ADC PARKS & GREENSPACE ARBORICULTURE CONSULTATION

PLANNING APPLICATION: FP/22/13/T

ADDRESS: 8 Ceres Place Felpham PO22 7RG

BRIEF DESCRIPTION: Fell 1 no. Sycamore

22 13 T
RECEIVED
25.2.13

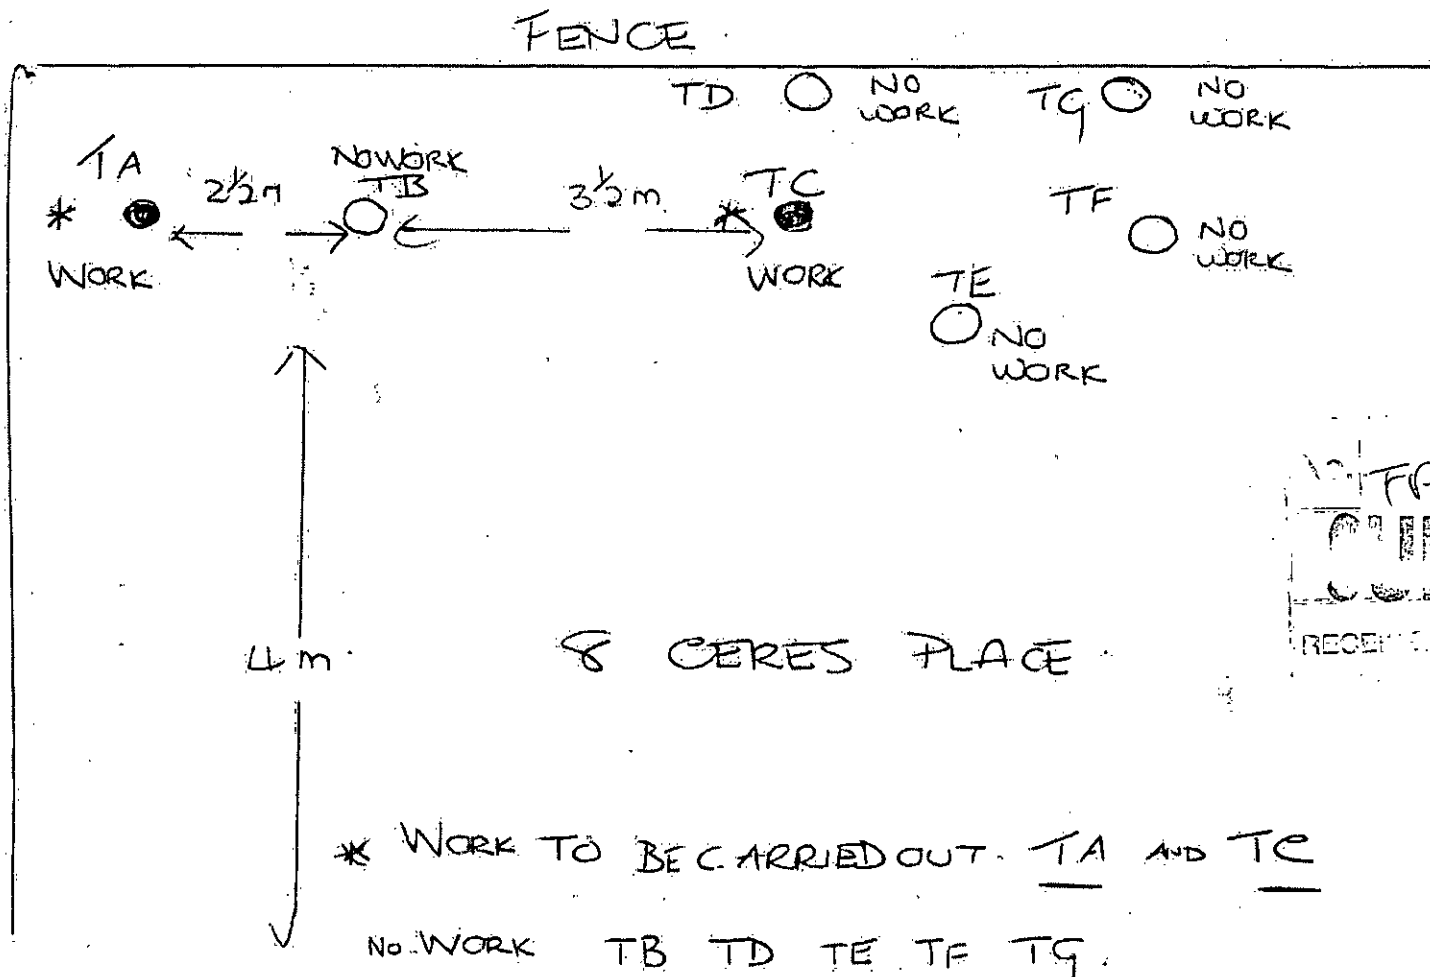
I visited the site and found several trees within the garden of the above property and a large dead and dangerous limb of a Monterey Pine extending into this property from an adjacent garden. There are two maps associated with this single application dated 8th February and 27th February. The description within the application does not match the work as indicated on the plan of 27th February where tree TA was marked for felling but was scribbled out.

I believe that tree TA is the mature Sycamore tree located in the corner of the rear garden between the small shed and side fence boundary. This tree is clearly visible from the highway providing visual amenity. Tree TA was found to contain some deadwood and damaged branches caused by the gnawing antics of Grey Squirrel. The tree has a healthy main stem and supportive primary branch structure. Removal of dead and damaged secondary branch growth is recommended but its removal has not been justified. In my opinion I doubt this was the original tree that the Arboricultural consultant 'Jonathan Rodwell' had priced to be felled as it is a very competitive price.

There is a smaller double stemmed Sycamore which I believe has been marked on the 8th February location plan marked as TC, located between a mature tree near to the rear fence and the Evergreen Oak. The tree is smaller in size than the one near to the shed. Its loss would however not detract from the visual amenity of the area and should be allowed consent.

The felling of Sycamore TA is unjustified and the amount in percentage for the crown thin of the Horse Chestnut has not been provided. The application should therefore be refused consent.
